Mark E. Jones, PE
Structural Engineering and Design

Ref: Site Observations and Analysis
122 Pondhurst Ln.
Fuquay-Varina, NC 27526
Project No. 24-059

The above referenced site was observed on June 19, 2024 for the following items:

FIRST FLOOR STRUCTURAL PLAN
 1/4" = 1'-0" CEILING HT. = 10'-0"

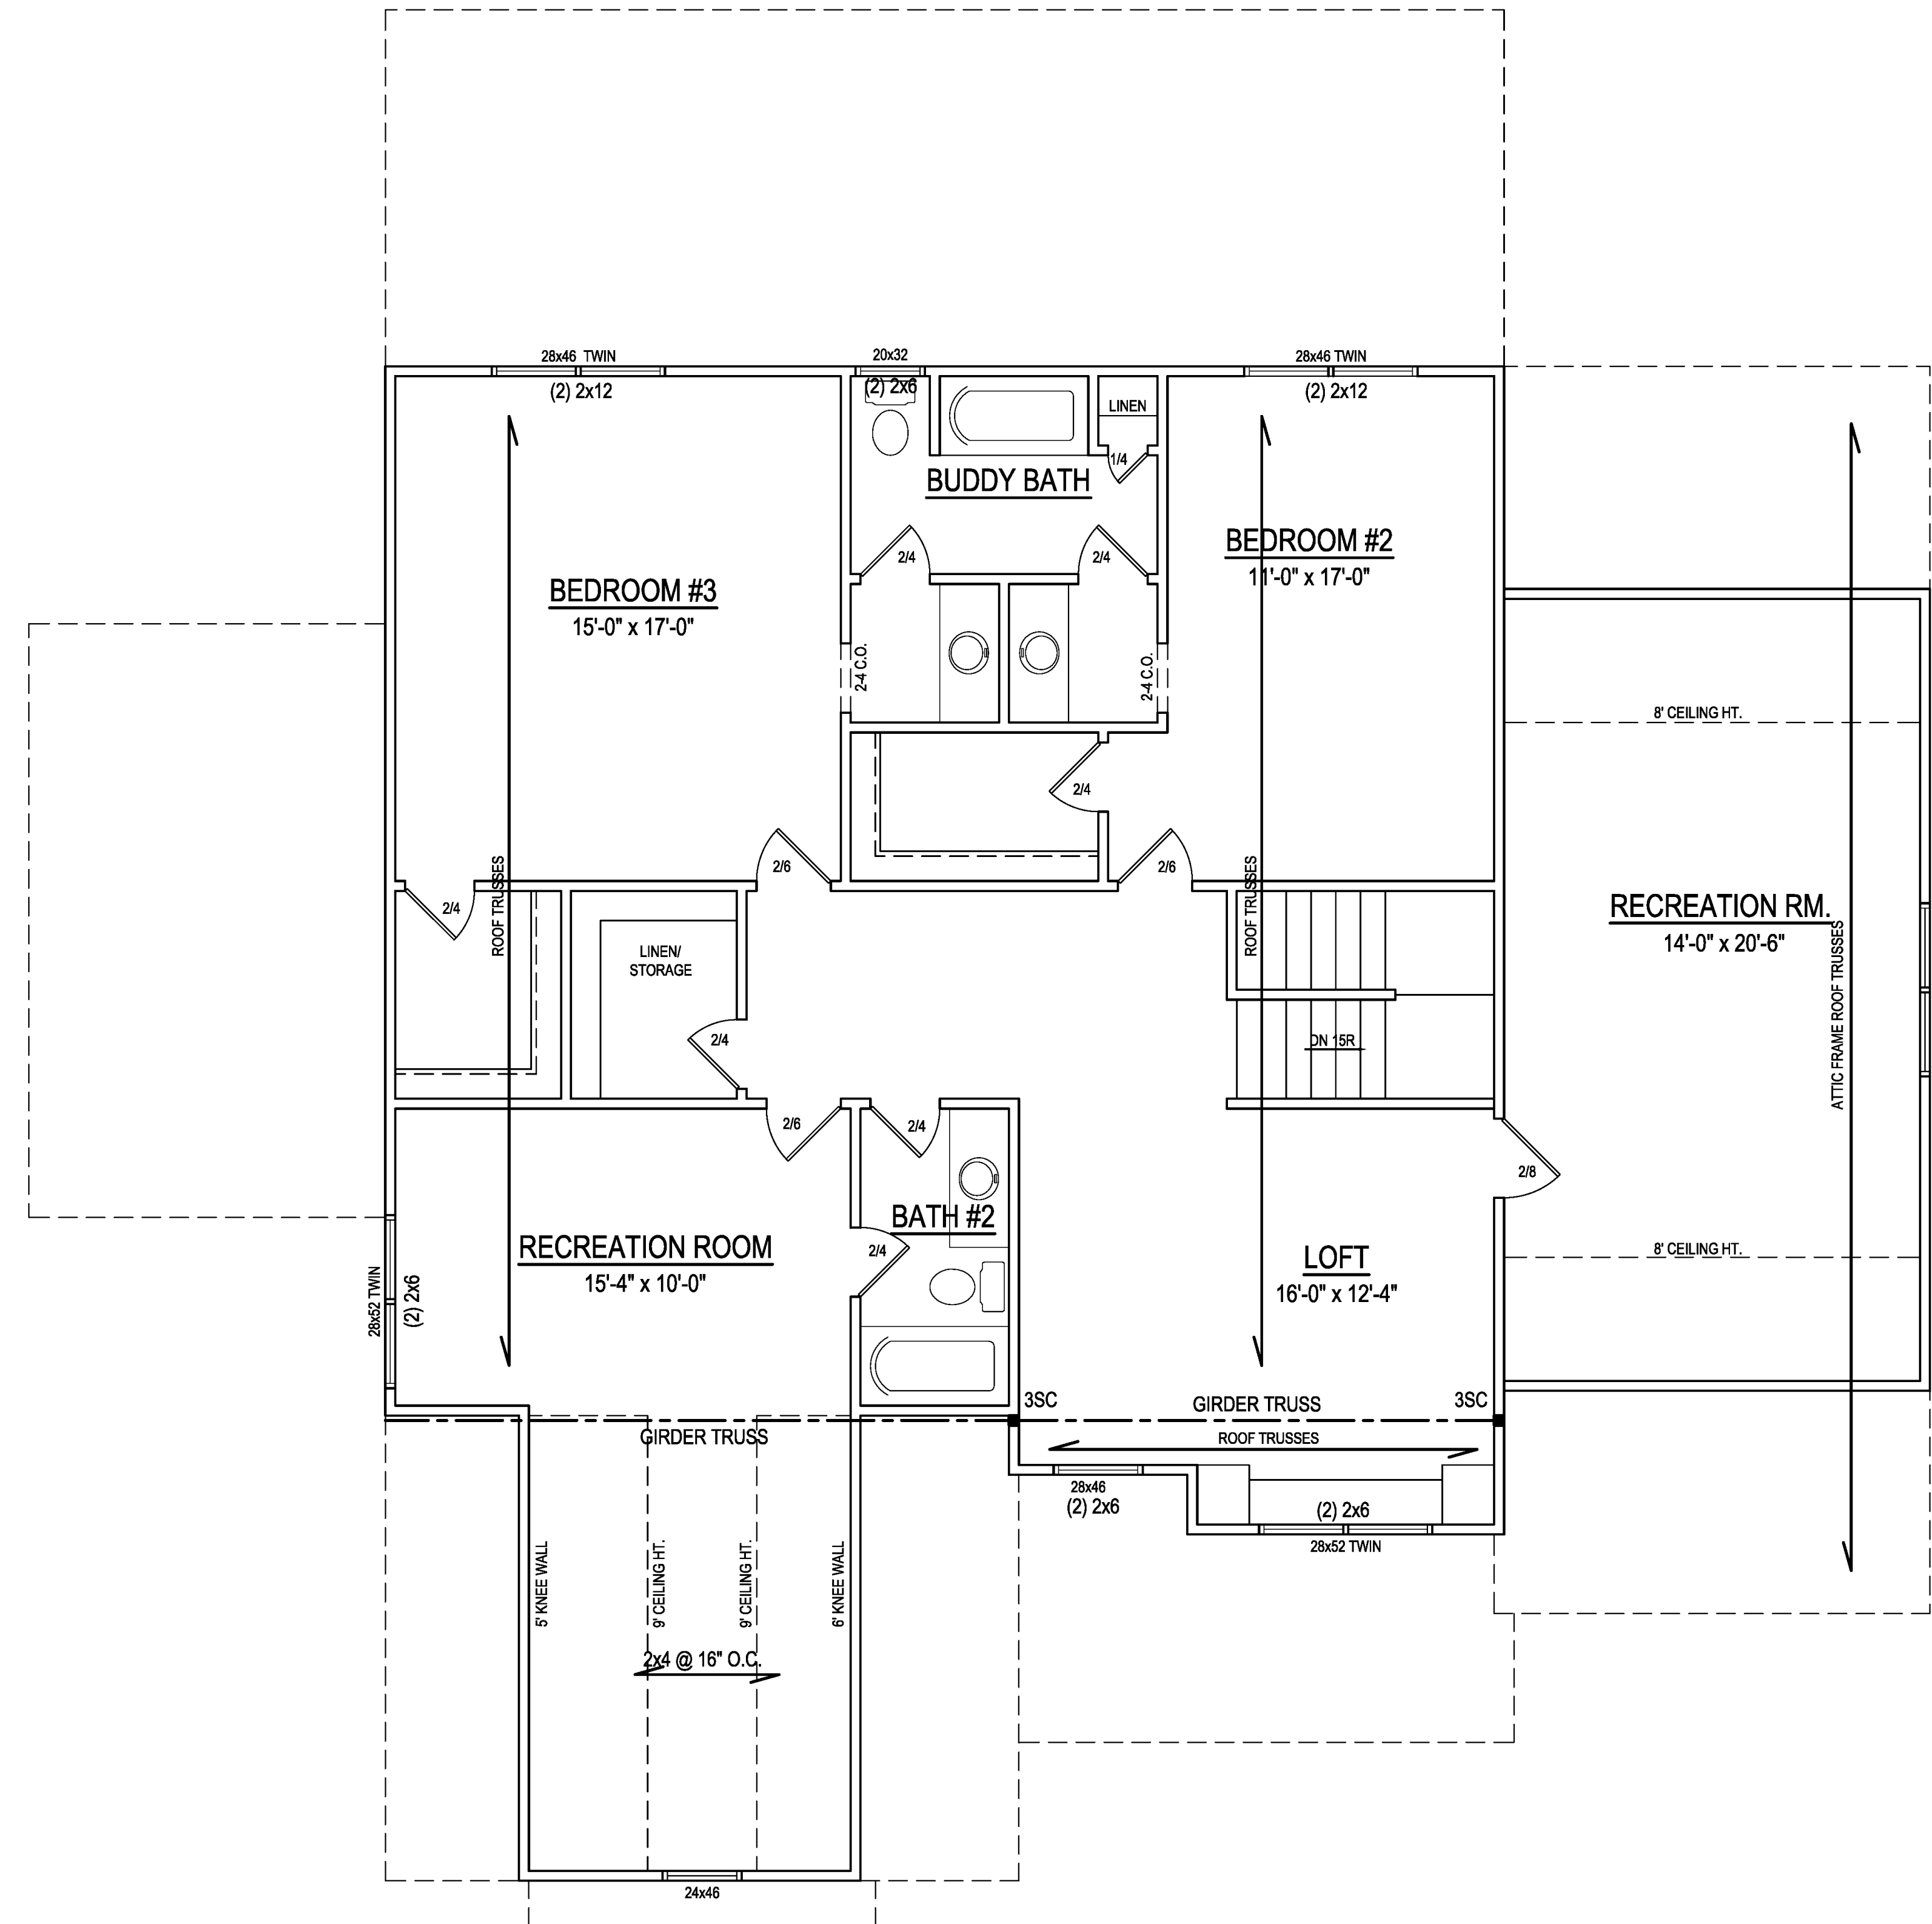
1. Garage 2x4 wall over 10' tall.
3. Cannot use short tico nails to attach hangers to double girder.

1. The builder has constructed the approximately 10'-11" tall walls at the garage with 2x4 studs spaced at 12" on center. The existing construction is adequate to support all imposed loads. No action is required.
3. The builder shall provide at least (10) 16d nails, (5) on each side, in the truss hangers supported by the double girder.
